BR/206/07

PLANNING APPLICATIONS REPORT

DESCRIPTION/	- Extension
ADDRESS	91 Chichester Road Bognor Regis

DESCRIPTION OF APPLICATION	Two storey side extension
SITE AREA	350 square metres approximately
RESIDENTIAL DEVELOPMENT DENSITY (NET)	N/A
TOPOGRAPHY	Predominately flat
TREES	None affected
BOUNDARY TREATMENT	Mixture of fencing and hedging
SITE CHARACTERISTICS	Semi-detached two-storey property with tiled roof
CHARACTER OF LOCALITY	Residential

BLOCK PLAN 1/500

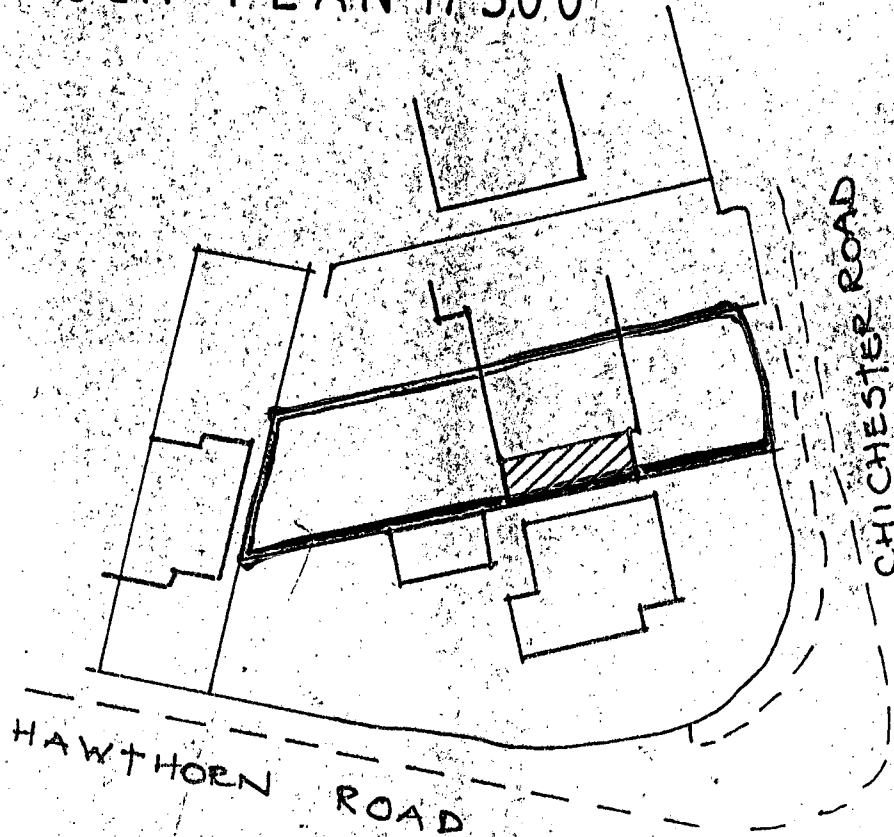
REASON 1 The proposal provides insufficient space between the flank wall of the dwelling and its site boundary. The Local Planning Authority consider that in respect of a two-storey building not less than one metre should be provided to protect the character and appearance of the street scene. The proposal is therefore in conflict with policies DEV1 of the West Sussex Structure Plan and DEV19, GEN7 of the Arun District Local Plan.

PROPOSED FIRST FLOOR PLAN

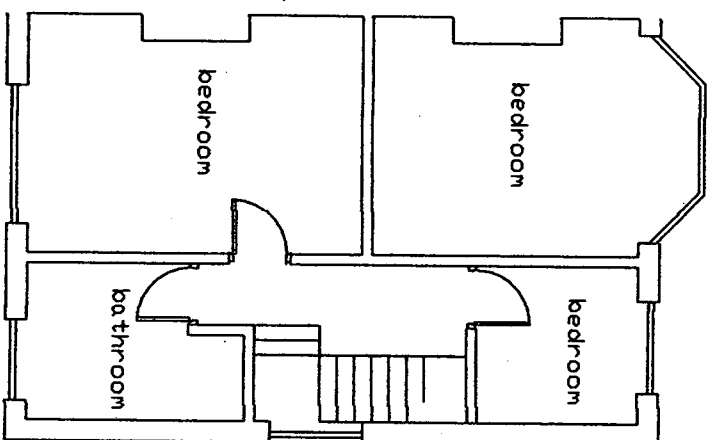
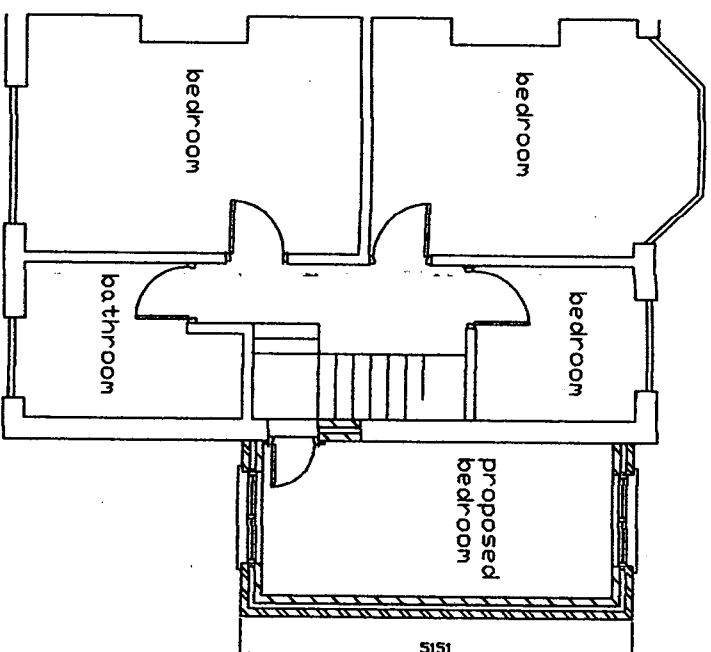
Nevertheless, Chichester Road is characterised by relatively small gaps at first floor level between buildings. Criteria 4 of *Policy DEV19: extensions to existing residential buildings* states in such a street scene, any extension at first floor level should not come to within a minimum of 1m of the side boundary, so as to avoid a terracing effect. The extension currently under determination does so, and it is for this reason that it is recommended the planning application should be refused, subject to the reason set out overleaf.
